Ribble Valley Borough Council
Council Offices
Church Walk,
Clitheroe
Lancashire
BB7 2RA

Phone: 0300 123 6780
Email: developeras@lancashire.gov.uk
Your ref: 3/2025/0845
Our ref: 3/2025/0845/HDC/KW
Date: 14 November 2025

Location: The Village Hall Franklin Hill Brockhall Village Old Langho BB6 8HY
Proposal: Proposed demolition of offices and construction of replacement office building.
Grid Ref: 370083 436655

Lancashire County Council acting as the Local Highway Authority (LHA) does not consider that the application as submitted fully assesses the highway impact of the proposed development and further information is required as set out in this response.

6020 - P01 REV -

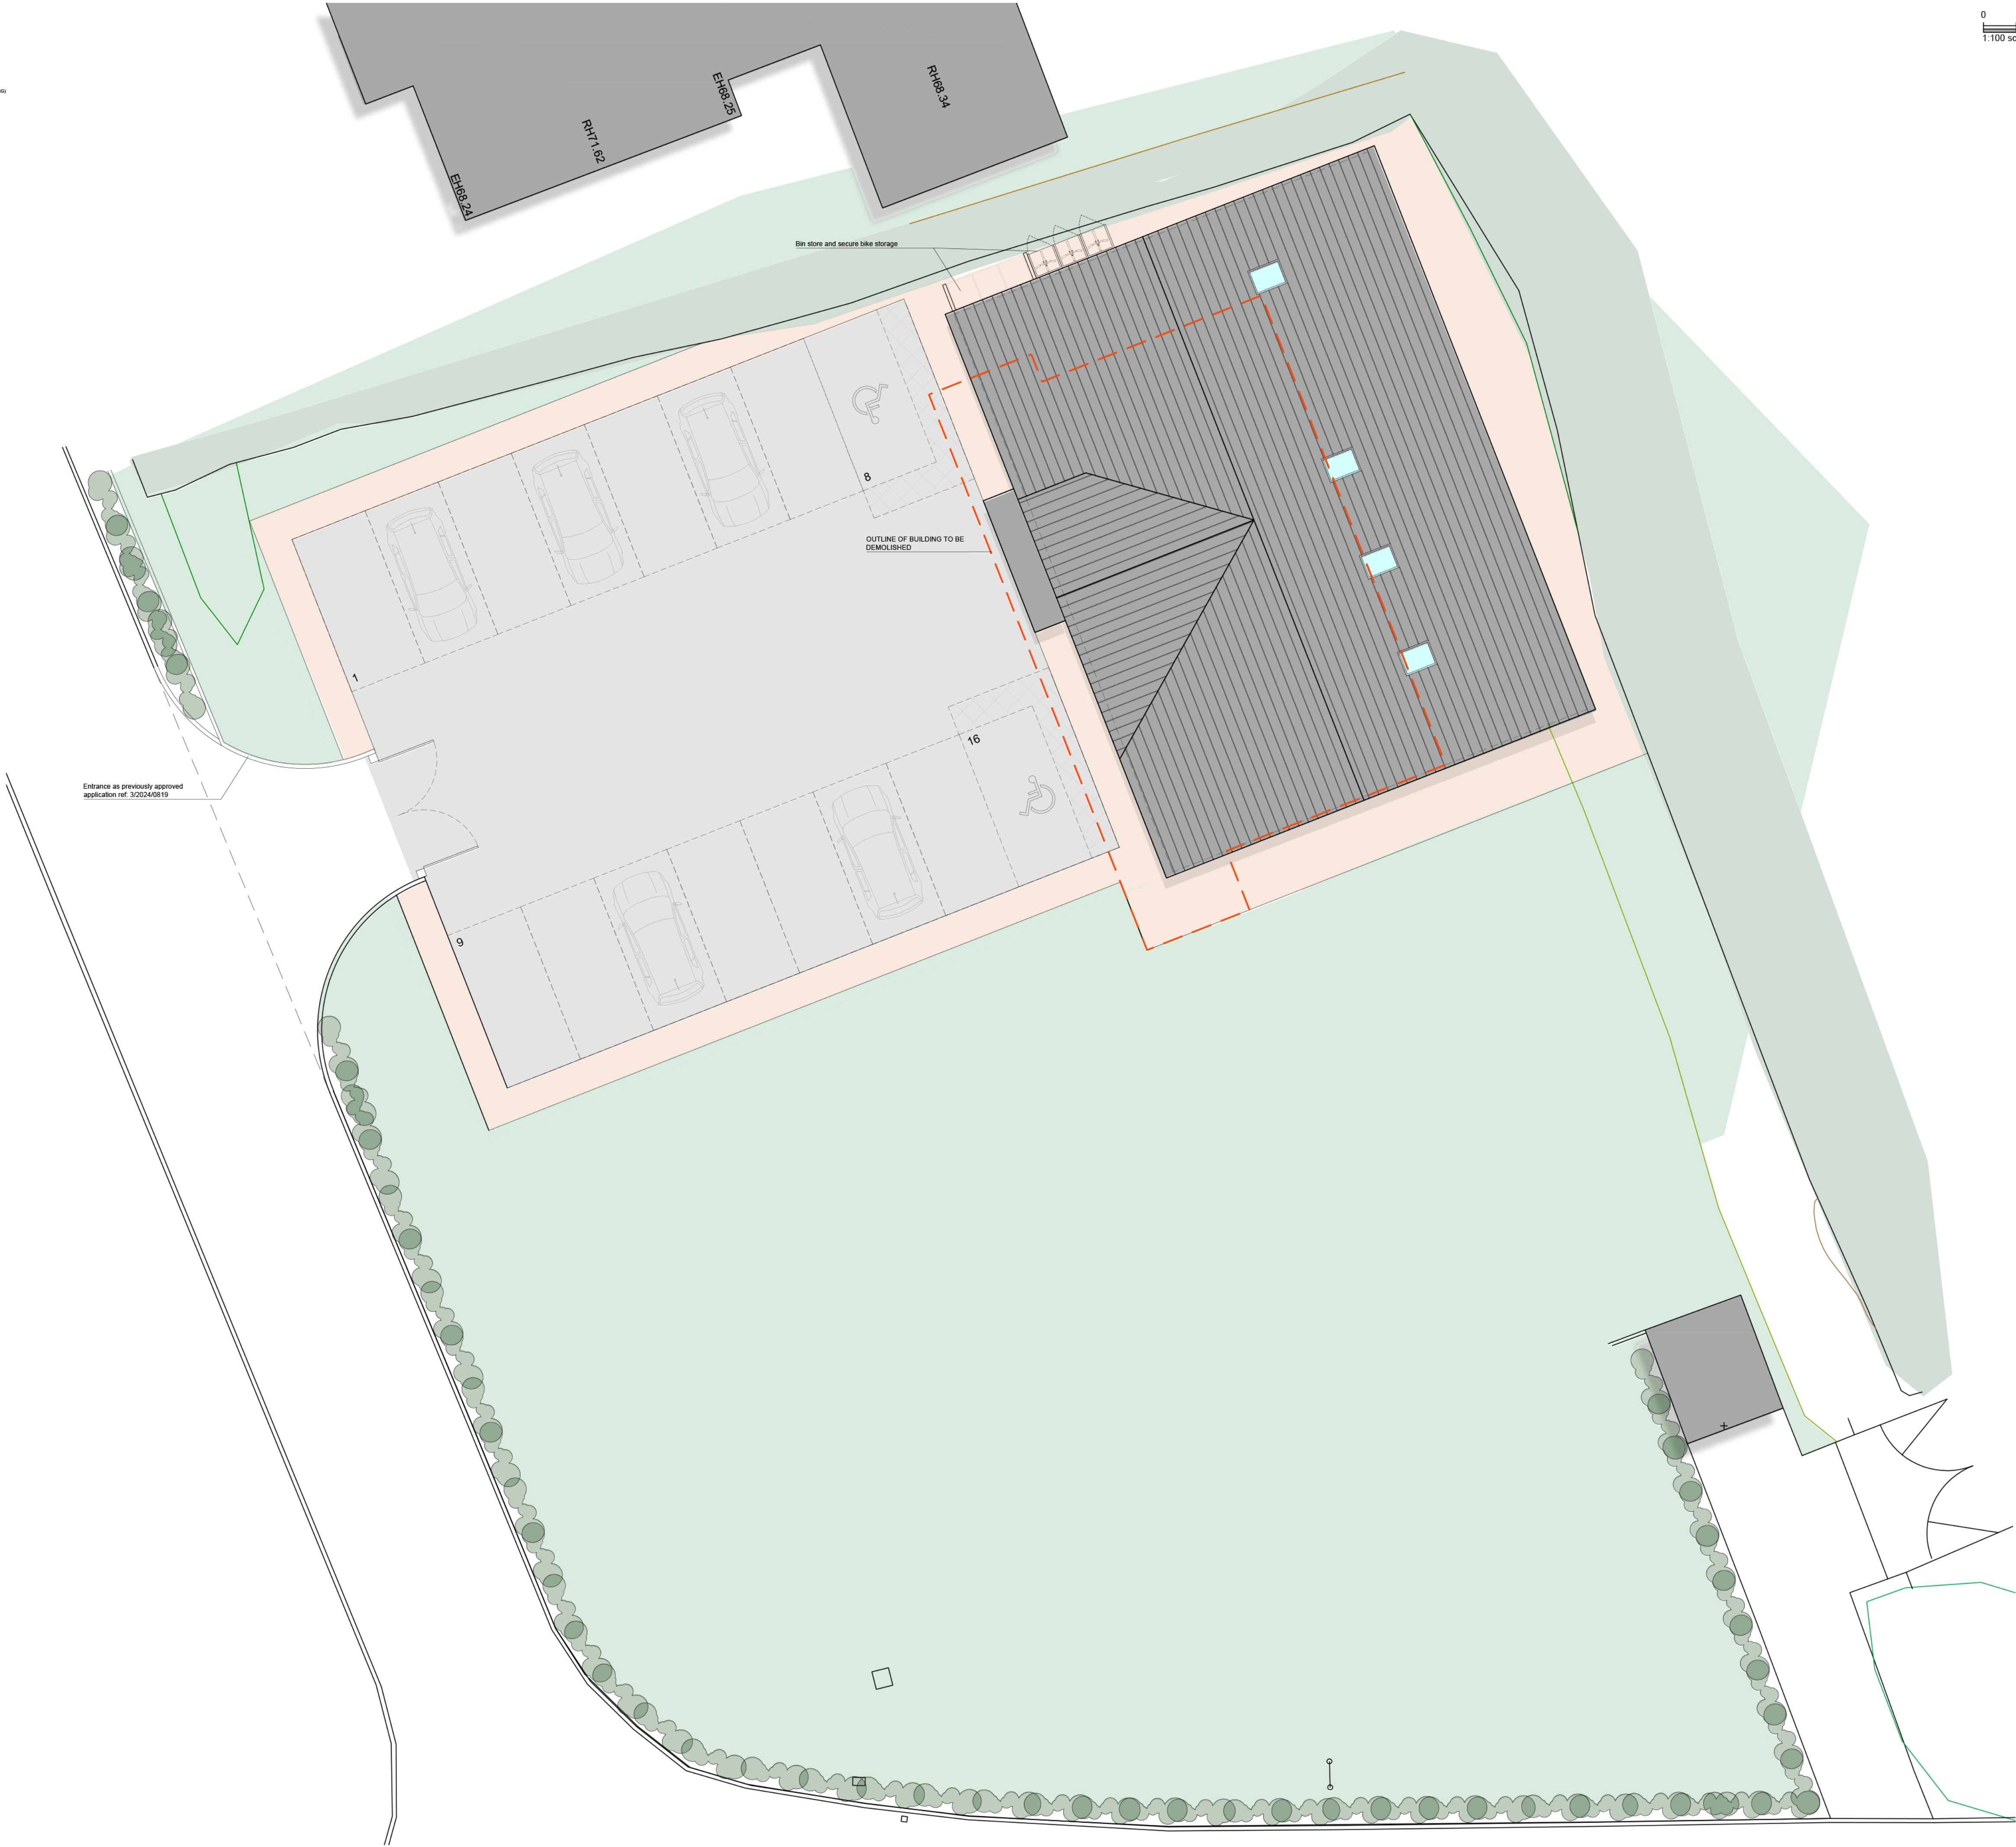
The access previously gained permitted development under application 3/2024/0819. However, the LHA would normally require the access to be a minimum of 5.5m wide. The LHA would also normally look for gates to be set back 5m behind the carriageway edge. This allows for 2 way movement and for vehicles to be able to operate the gates without overhanging the carriageway.

There is also no footway provision around the access; the LHA would request that a 2m pedestrian footway be created around the access to support safe pedestrian movements into the site and for the footway to be tied into the existing footway provisions on the wider network.

The LHA have reviewed drawing number 6020 – P01 titled Proposed Site Plan and which shows a total of 16 off street parking spaces made up of 14 normal parking bays and 2 disabled parking bays. Each parking bay measures approximately 2.4m wide and 5m long. The proposed disabled bays (marked bays 8 and 16) have also been provided with an approximate 1m access zone. Although the access zone should be 1.2m wide in line with inclusive mobility guidance, whilst not marked, there is 1.2m of unobstructed width provided next to each bay.

There are, however, concerns regarding vehicle parking spaces marked numbers 1 and 9, which are obstructed by the site access gates, making them unlikely to be utilised.

The LHA would look for the footways within the development to be in line with inclusive mobility guidance; as such the LHA would look for 2m footways throughout the site. An absolute minimum of 1m over short distances of up to 6m if there are localised obstructions such as trees and street furniture can be acceptable. As such the LHA would request that the internal footways provisions are reviewed and amended where required.

forms of transport. The LHA note that secure cycle storage is provided to the North of the site. Additionally, due to the nature of the application, it is expected that charging points for electric vehicles be included in the development to promote sustainable modes of transport. The DfT guidance regarding Electric Vehicle Charging in Residential and Non-residential buildings states charge points must have a minimum power rating output of 7kW and be fitted with a universal socket that can charge all types of electric vehicles.

In conclusion, while the proposed internal layout broadly complies with parking standards and allows for safe vehicle manoeuvring, concerns remain regarding the adequacy of the access arrangements, particularly the lack of safe pedestrian access from the wider network. Additionally, two parking bays appear obstructed and may not be usable in practice, reducing the total of off-street parking spaces to 14 spaces.

The LHA also recommends that internal footways be reviewed to ensure compliance with inclusive mobility guidance, with a preference for 2m widths throughout the site and to support pedestrian movement into the site. Furthermore, to support sustainable transport objectives, the development should incorporate electric vehicle charging infrastructure in line with national guidance.

As such, revised plans should be provided to resolve the outstanding issues.
